Application No: FG/54/22/PL
Site Address: Land rear of 1 Sea Drive Ferring BN12 5HD
Description of works: 1 No new dwelling. This application is in CIL Zone 4 and is CIL Liable as new dwelling.

Thank you for your internet representation made on 22nd April 2022 which has been recorded as an objection with the comments as follows:

Proposed Site Plan
Scale 1:100 @ A1

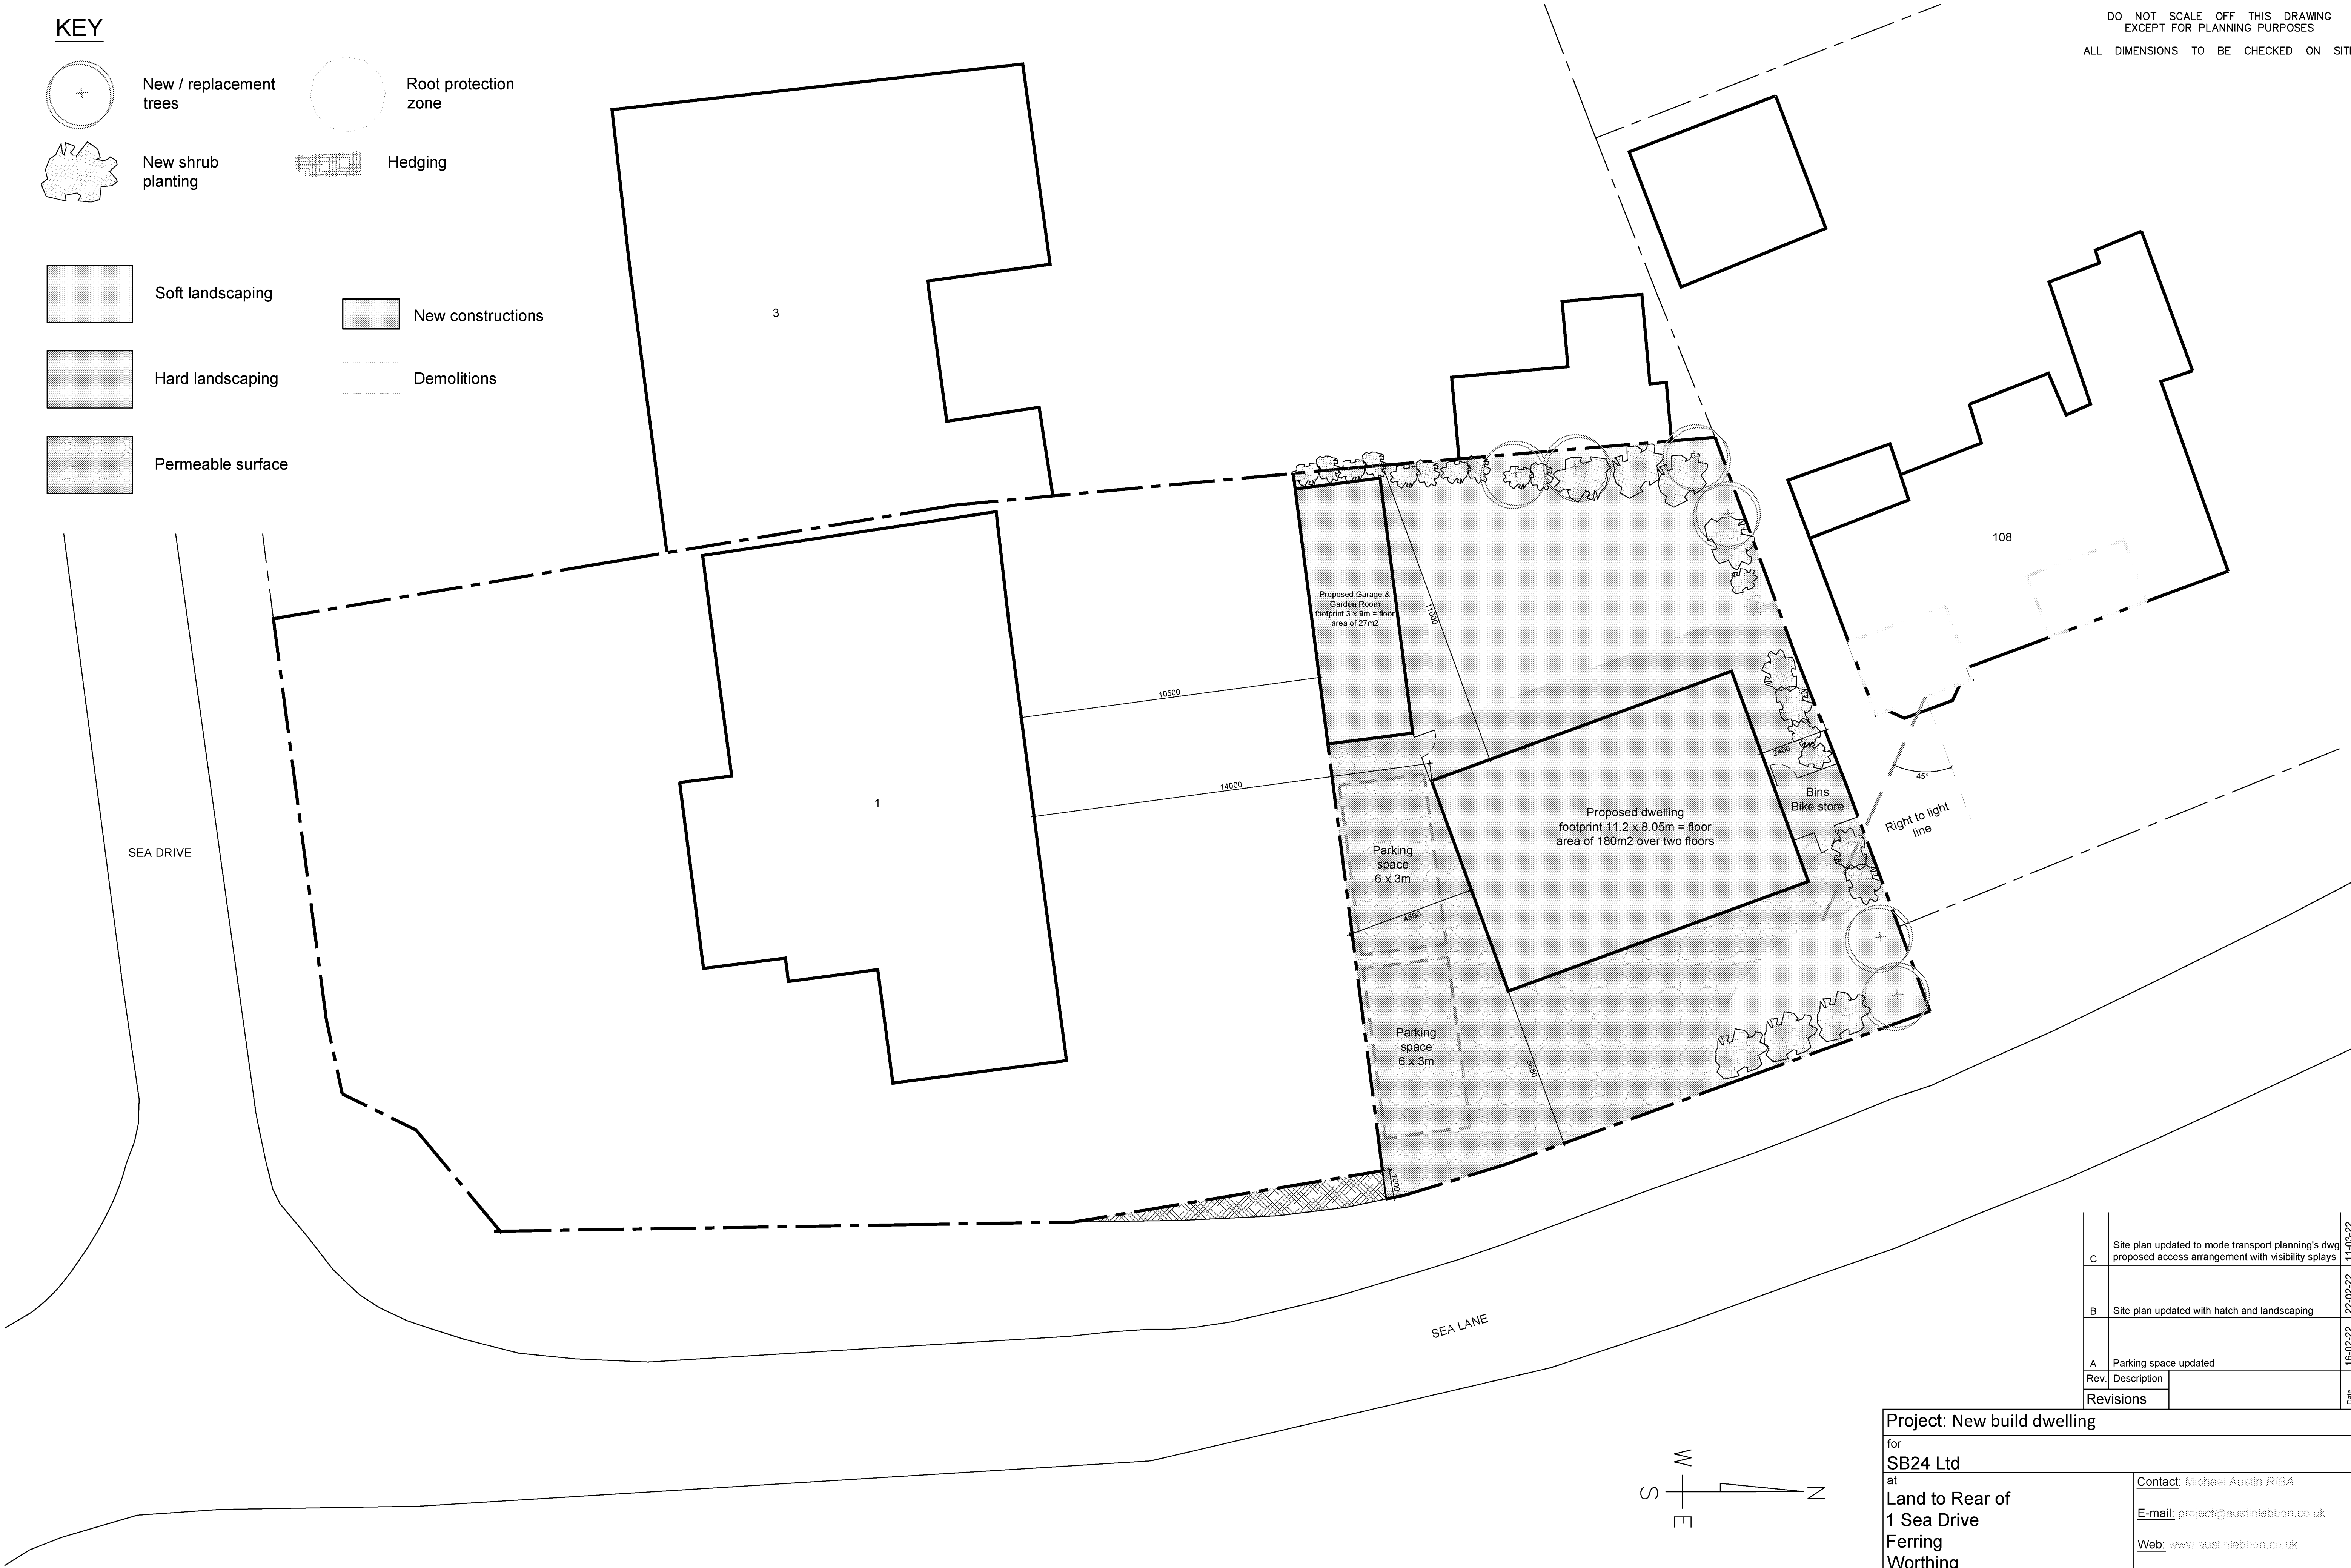
As has been mentioned by many other objectors, the proposed new access from Sea Lane would be at a dangerous point in the road - so dangerous that when Highways visited to assess the original design of the block of flats proposed on this plot under FG/198/16/PL, the inspector commented that he was shocked at how cars disappear from view for several seconds when rounding the bend - whether going South towards the seafront or rounding the bend to head North up Sea Lane. That scheme was immediately revised to remove the access from Sea Lane and introduce underground parking, which would have been a far more costly option and would presumably only have been done on the threat of a refusal on Highways safety grounds.

Sea Drive on the right and often take the bend wide, travelling on the wrong side of the road. Adding an additional access at this point in a road would be hazardous but one that necessitates cars to be reversing into the oncoming traffic would be ludicrous !

The fact that cars would be unable to turn on the plot itself demonstrates how cramped in this new house would be - it only fits if pulled substantially forward of the building line of Sea Lane. A house to the south of 108 and 106 Sea Lane, sitting forward of those neighbouring properties to such a degree, would have the effect of blocking a great deal of light and outlook from those properties and their gardens.
